PLANNING WORKSHEET 11 – DELEGATED / PCG REPORT - HOUSEHOLDER

Application Ref.	22/00690/HSE	
Site Address	East View 7 Bar Road South Beckingham Doncaster South Yorkshire	
Proposal	Two Storey Side Extension	
Case Officer	Eleanor Grant	
Decision Level	Delegated	
Reason(s) for PCG referral		
PCG Sign off and date		
	Signature	Date
Case Officer	Ellie Grant	05/07/2022
Principal Planner		
Authorised signing Manager		7 th July 2022

Drawing Title  
**PLANNING PROPOSAL**  
 7 Bar Road South  
 Beckingham

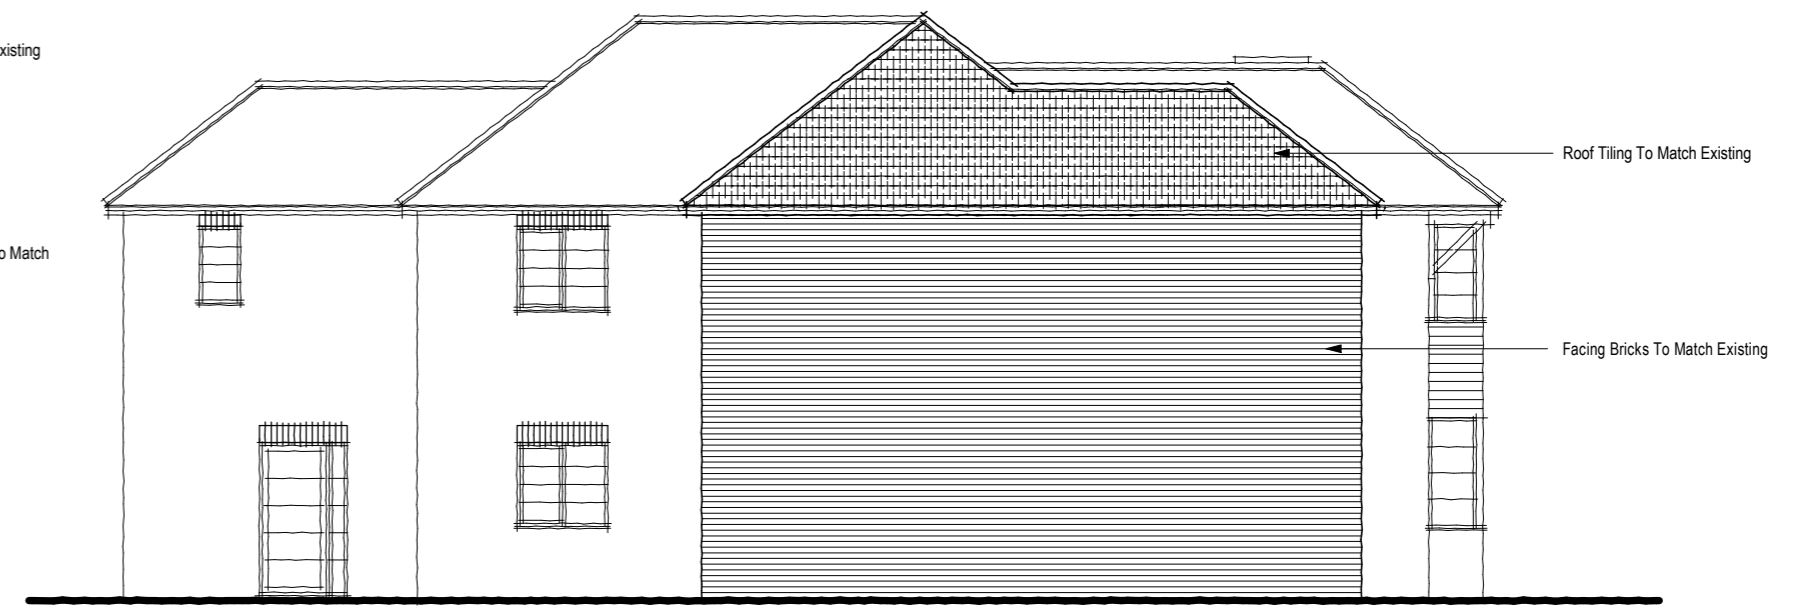
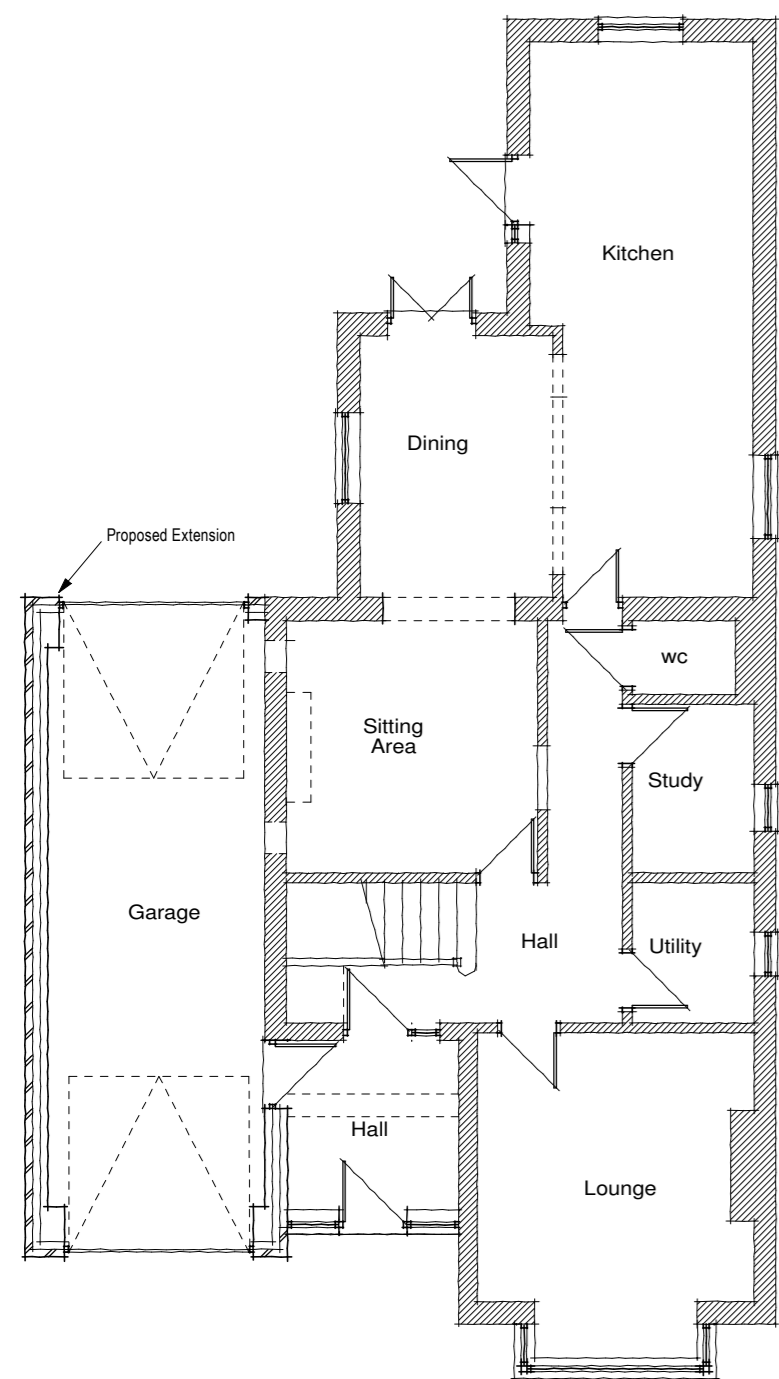
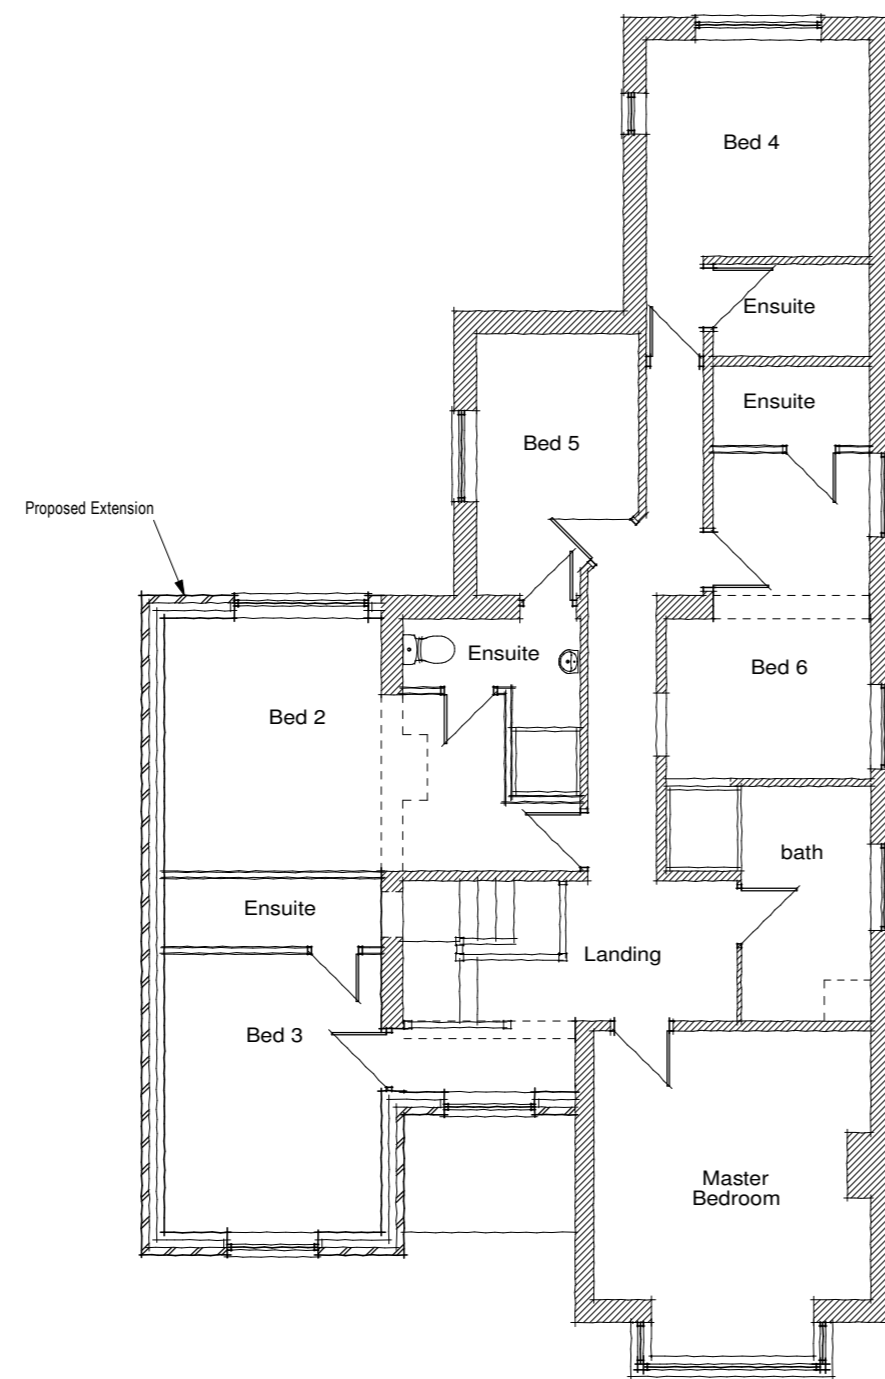
The extension will be on the south-east elevation, over the existing driveway that leads to a garage at the rear. It will have a drive through garage at ground floor level and residential accommodation above. To accommodate the extension, there will be a small first floor extension to the area above the porch to form a first floor hallway.

Though the extension will make the house appear larger, it will be set back from the principal elevation and will be of a reasonable scale which does not dominate the original house. The property has an adequate parcel of land to ensure that there is still sufficient outdoor amenity space.

The extension will be constructed of brick to match the original house and will widen the hipped roof. The roof will step down to accommodate the smaller projection into a smaller front hip. This will match the form and appearance of the original roofline.

The block plan indicates extension will be approximately 0.5 metres from the shared boundary, whilst the existing dwelling Treways is positioned around 1.5 metres from the boundary. Treways has 6 windows on the elevation facing the shared boundary, which are all obscurely glazed:

The Officer was concerned that the extension would pose a loss of daylight to these windows therefore visited to ascertain whether they serve habitable rooms.

On visit, the first floor windows serve a bathroom. The ground floor windows (from front to rear) serve a secondary window into a habitable room, a small utility room/study (currently empty), downstairs toilet, and secondary windows into the kitchen (there are two large windows serving the kitchen at the rear). As these windows are not primary windows into habitable room, the potential loss of daylight is considered to pose limited harm.

There is no risk of overshadowing to the windows to the rear as it will not project beyond the original rear building line of the property (prior to extension).
